KITTITAS COUNTY

DEPARTMENT OF PUBLIC WORKS

MEMORANDUM

TO: All Staff
FROM: Public Works Plan Review Team
DATE: September 13, 2024
SUBJECT: SP-24-00012 Sedgwick

SEDGWICK SHORT PLAT

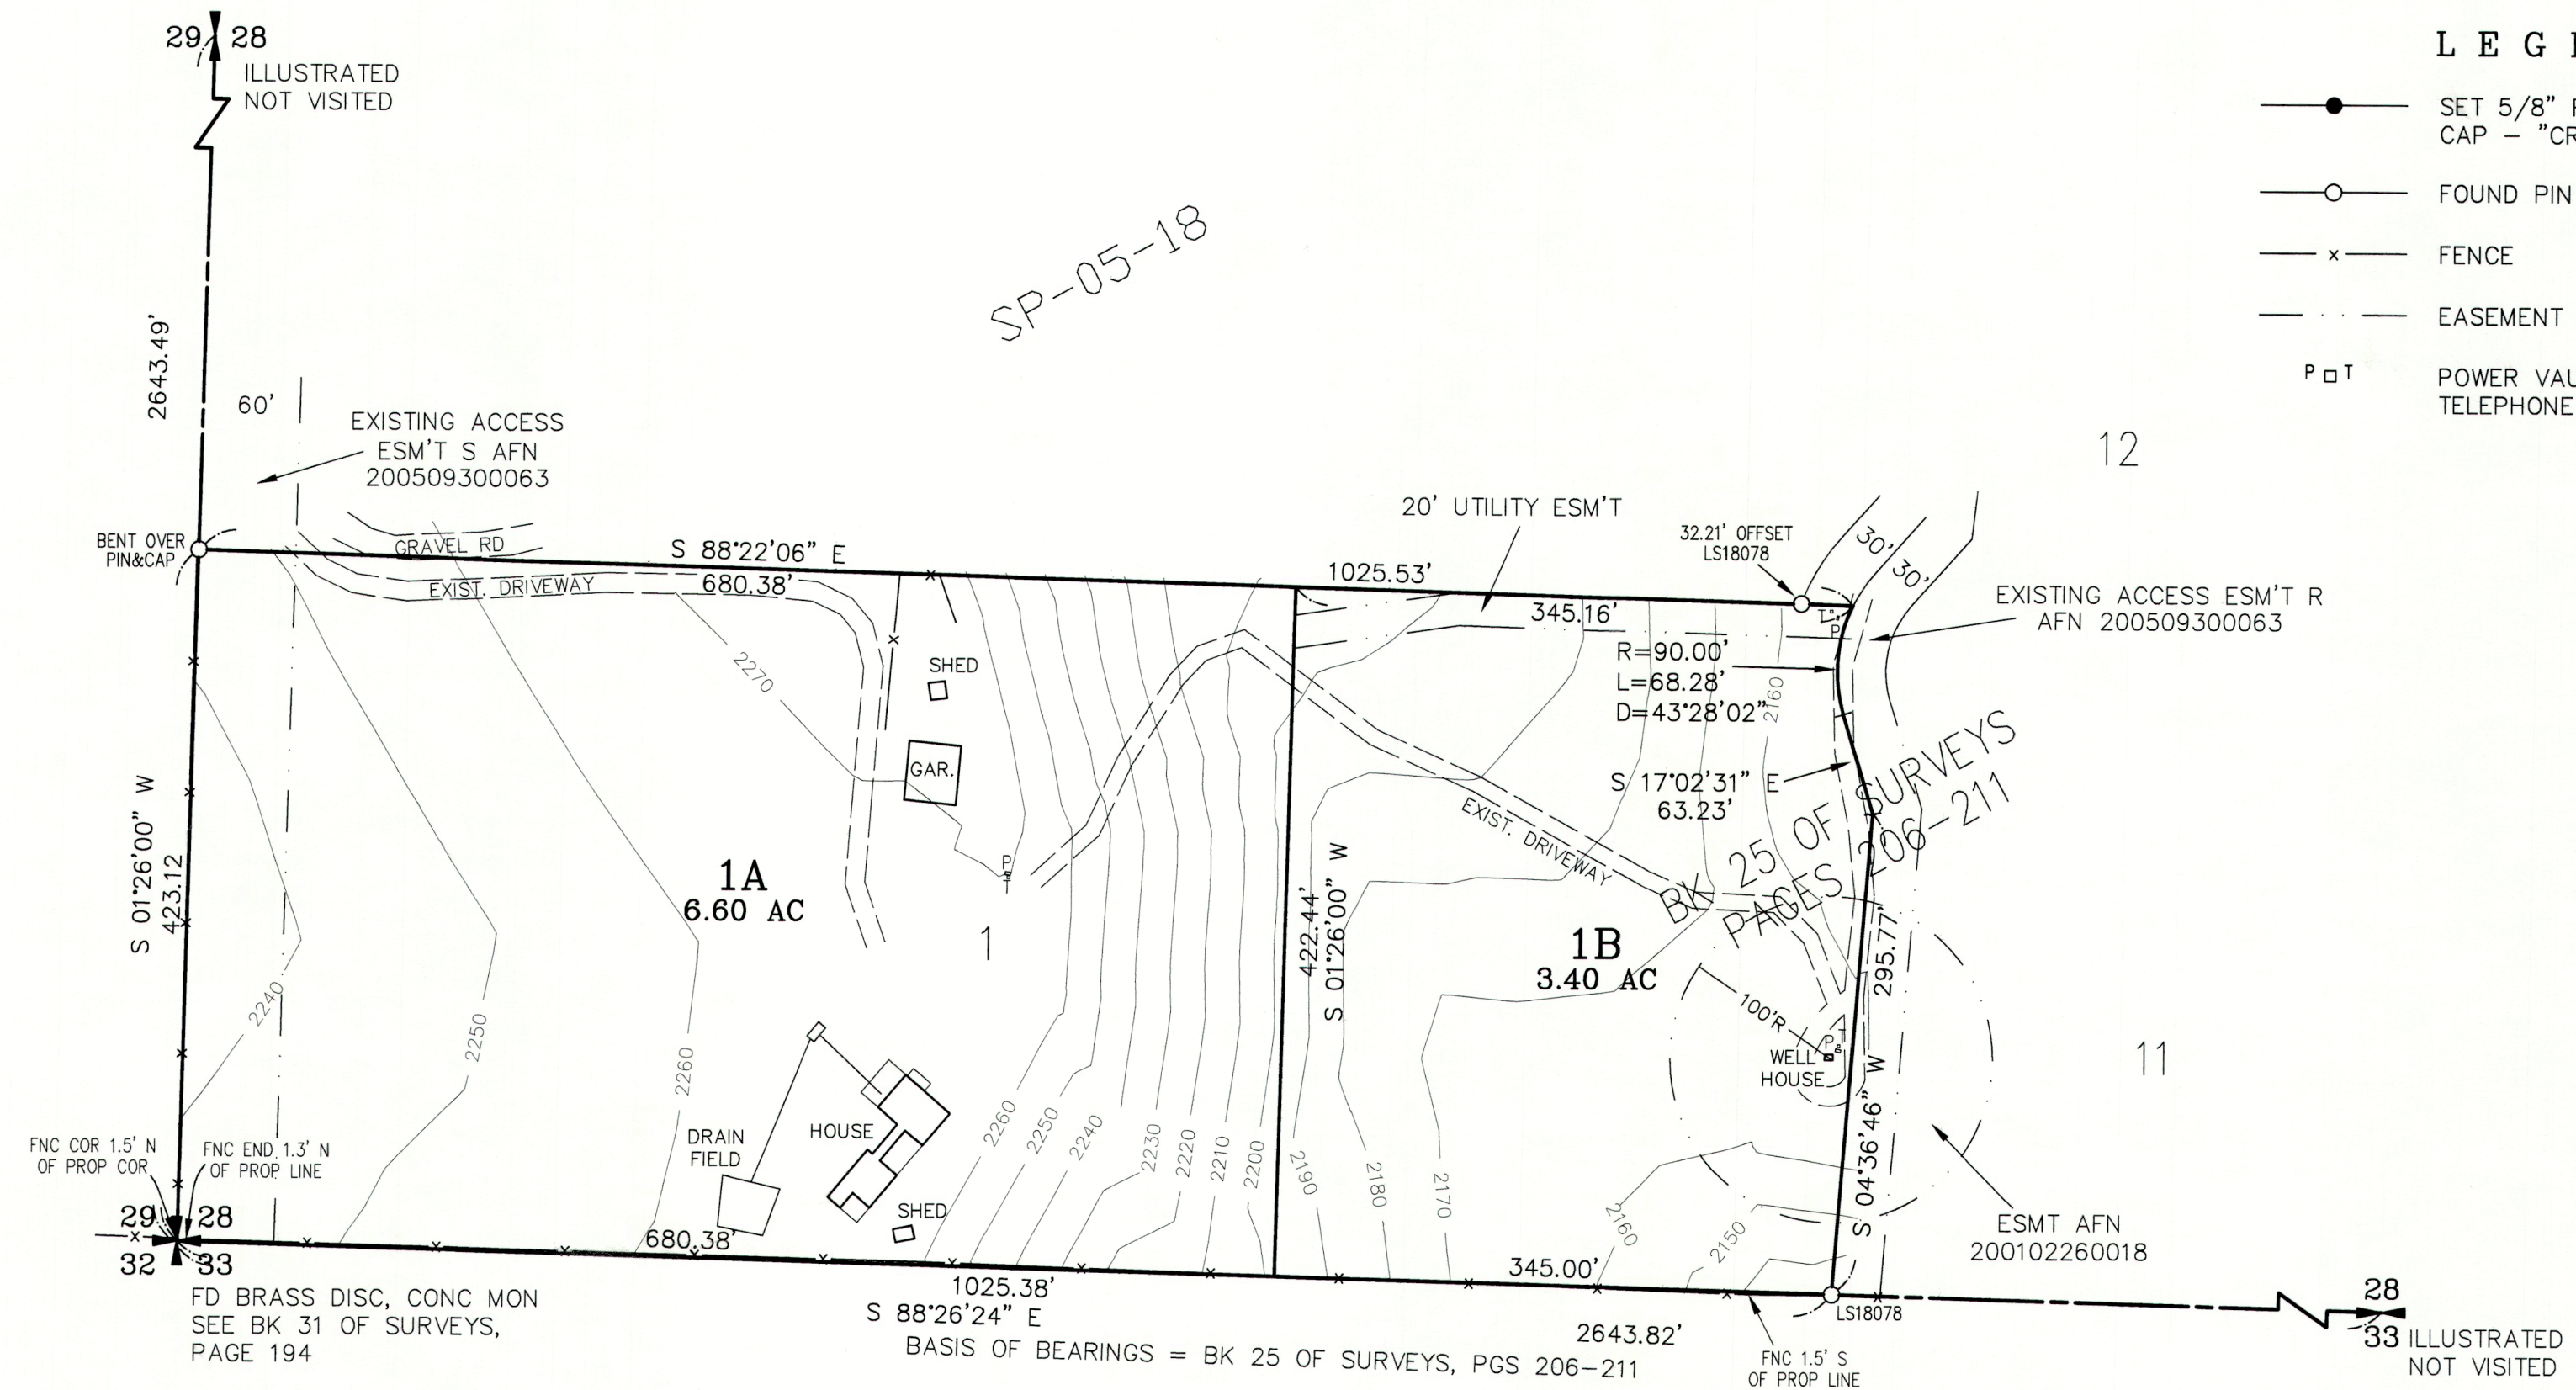
ACCESS	<ol style="list-style-type: none">1. An approved access permit shall be required from the Kittitas County Department of Public Works prior to creating any new driveway access or altering an existing access.2. Maintenance of driveway approaches shall be the responsibility of the owner whose property they serve. The County will not maintain accesses.3. Any further subdivision or lots to be served by proposed access may result in further access requirements. See Kittitas County Road Standards.4. In addition to the above-mentioned conditions, all applicable Kittitas County Road Standards apply to this proposal. Access is not guaranteed to any existing or created parcel on this application.5. Mountain Creek Drive and Fir Tree Drive were certified to High Density 3-14, 0–5-acre average lot size with roadway width of 20 feet. Further plat development may change the road certification requirements to 15-40 average lot size 0–5-acre requirement of 22 feet. (JS) <p>OF NOTE: Existing address of 1690 Mountain Creek Drive to be assigned to parcel 1A upon recording of the short plat.</p>
